**RE: Response to Request for Information for SSD 8588  
Eastern Creek Business Hub (Lot 2)**

Ethos Urban has prepared this letter on behalf of Frasers Property Australia in response to your letter dated 7 December 2017, and the associated submissions received during the exhibition period of SSD 8588 and SSD 5175 MOD 3, relating to Lot 2 of the Eastern Creek Business Hub development.

AERIAL VIEW FROM APPROVED ACCESS ROAD

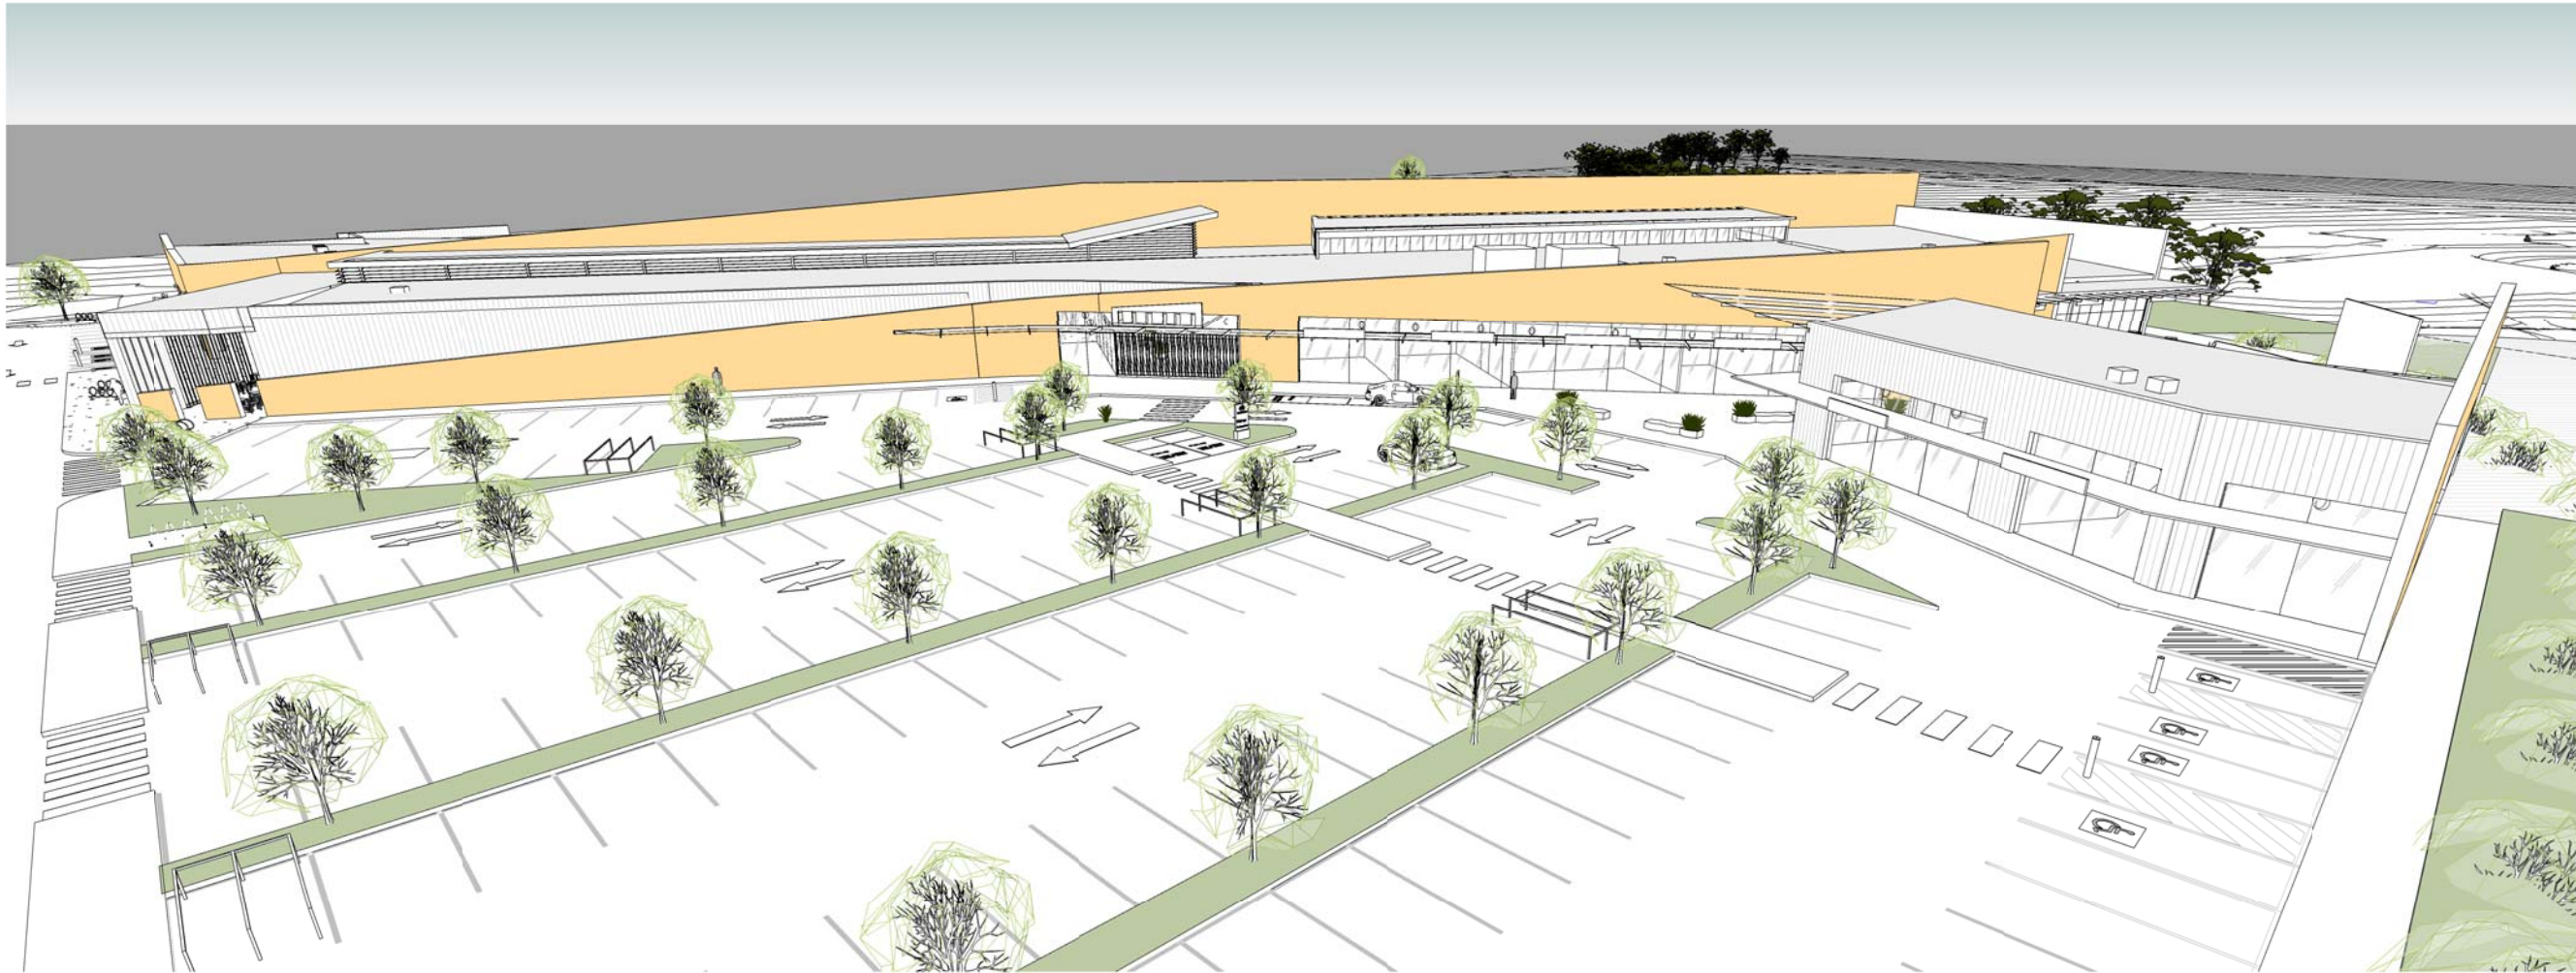
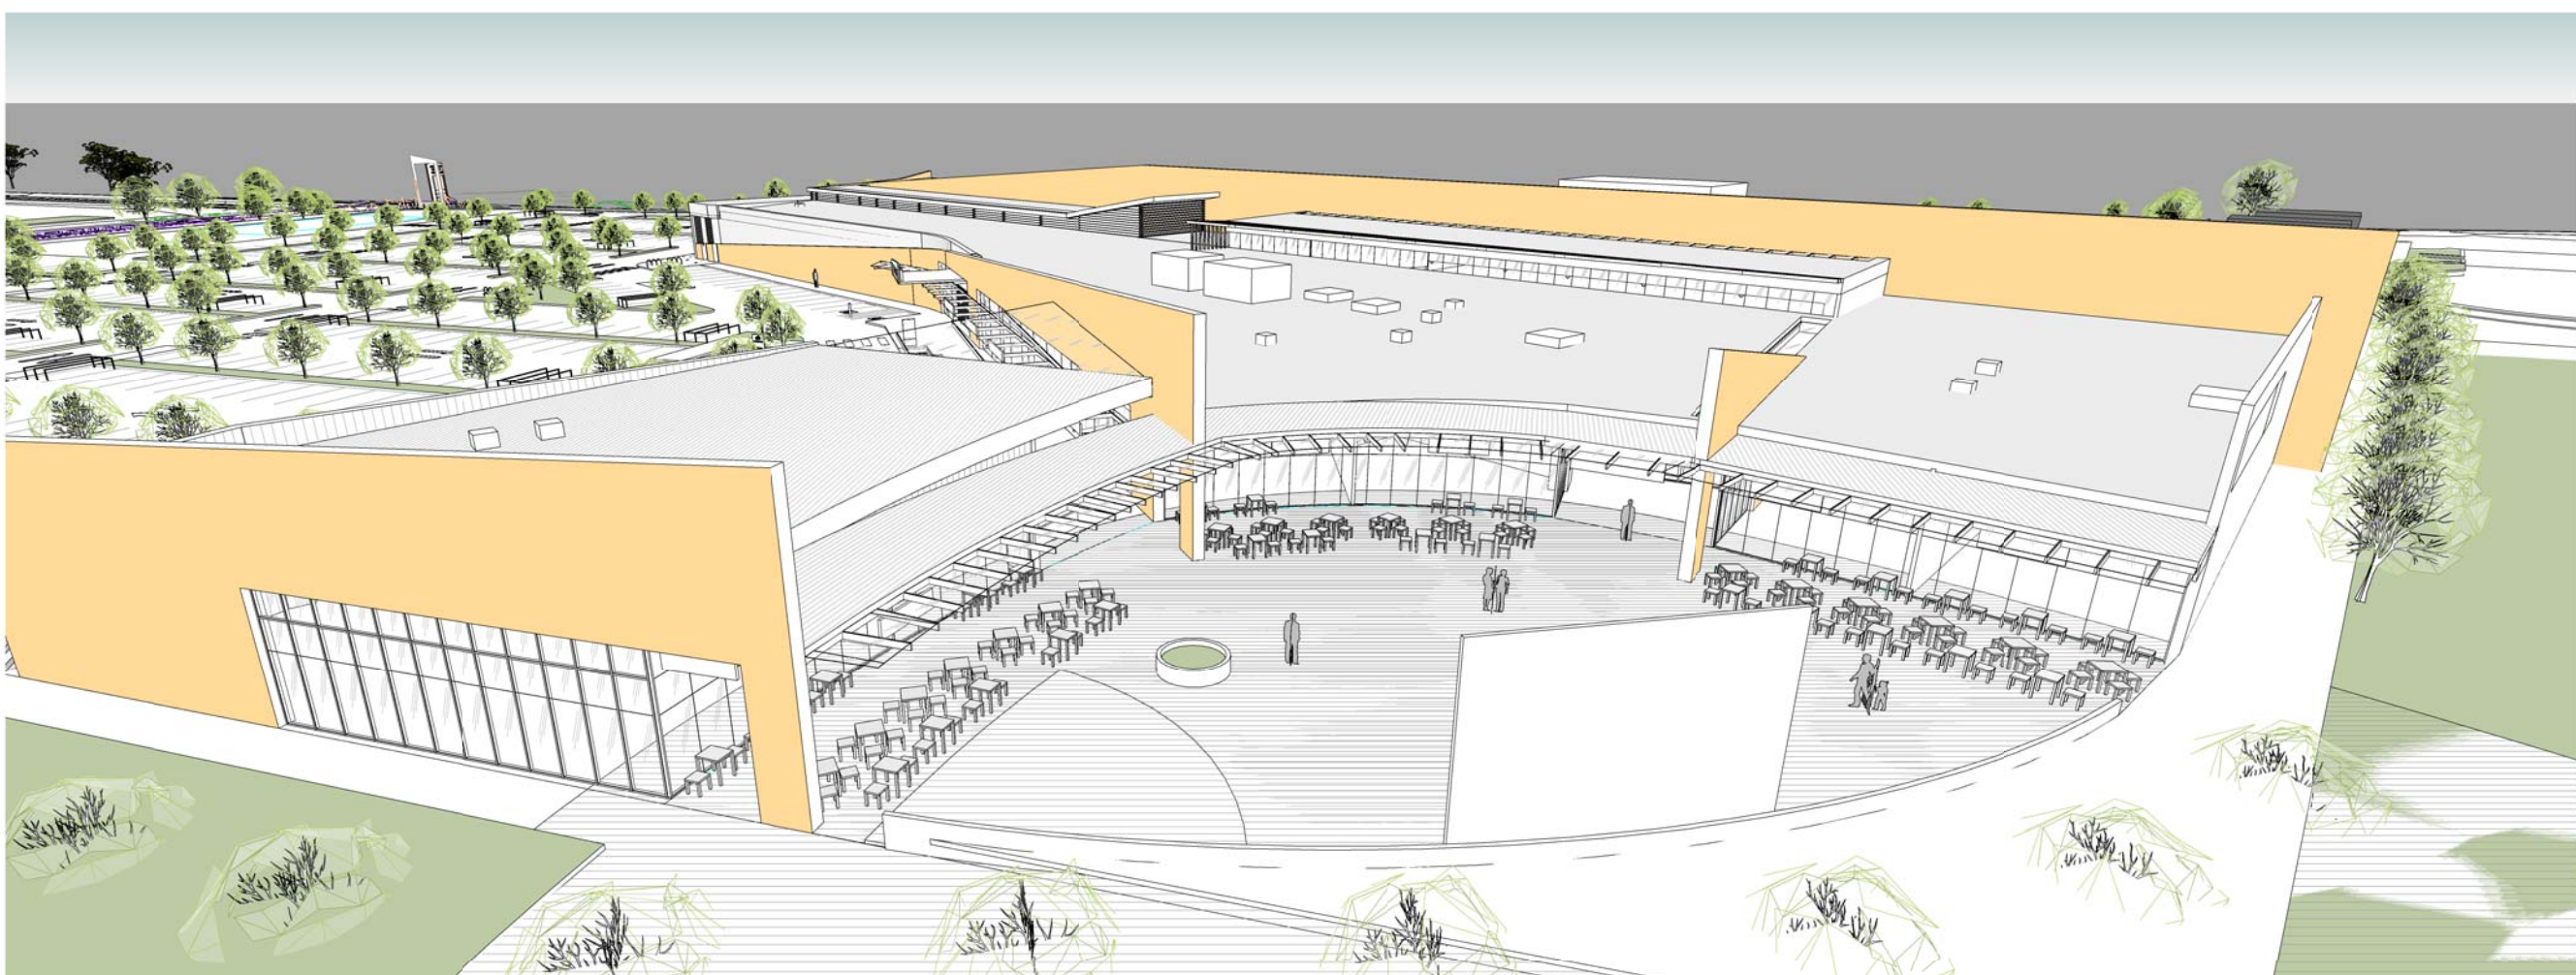
DPE Comment	Response
<b>Schedule 1 – Key Issues</b>	
<b>Visual Impact/Streetscape</b>	
<p>1. The following additional information has been requested:</p> <ul style="list-style-type: none"> <li>• Details of the location, type, material and finishes of the proposed acoustic wall and landscape treatment along RHRS.</li> <li>• Details of the materials and finishes for the shopping centre building.</li> <li>• Images at key locations showing building and material components and finishes and supported by an architectural design statement.</li> <li>• Additional aerial 3D perspectives showing the interface along RHRS, including the loading dock and the acoustic wall and landscape setback.</li> </ul>	<p>I2C has prepared Materials and Finishes Package (refer to <b>Attachment A</b>) that provides additional details of the location, type, materials and finishes of the proposed wall along Rooty Hill Road South and the retail centre building. This is accompanied by additional aerial perspectives (<b>Attachment B</b>) showing the interface along Rooty Hill Road South and an Architectural Design Statement (<b>Attachment C</b>) outlining the rationale behind the proposed building materials, lighting and screening.</p>

EXISTING RESIDENCE LONG SECTION C 1 : 100

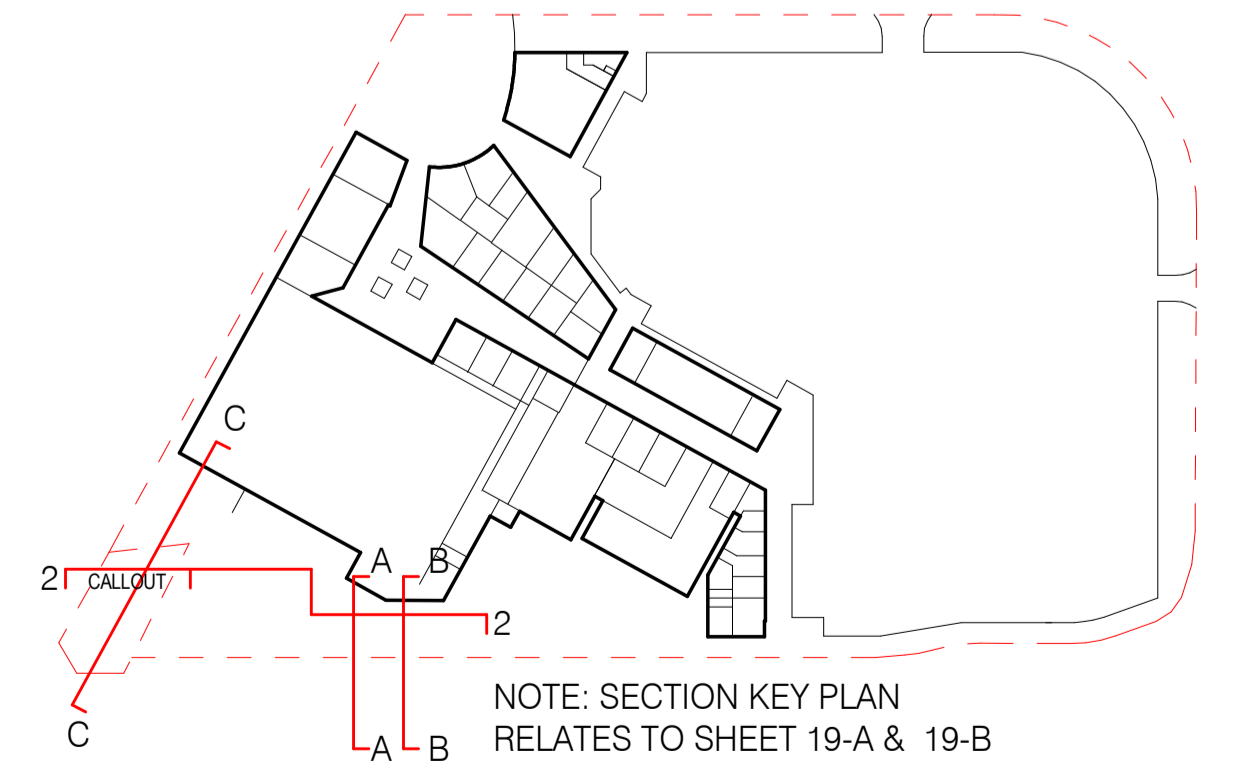
<b>Schedule 2 – Additional Information</b>	
<ul style="list-style-type: none"> <li>Provide section plans through the adjoining residential lot boundaries on Beggs Road and the loading dock including acoustic treatment, landscaping, driveways and the shopping centre building.</li> </ul>	<p>I2c has prepared additional section plans and perspectives (refer to <b>Attachment H</b>) showing the design of the loading dock in relation to the neighbouring residential lots.</p>
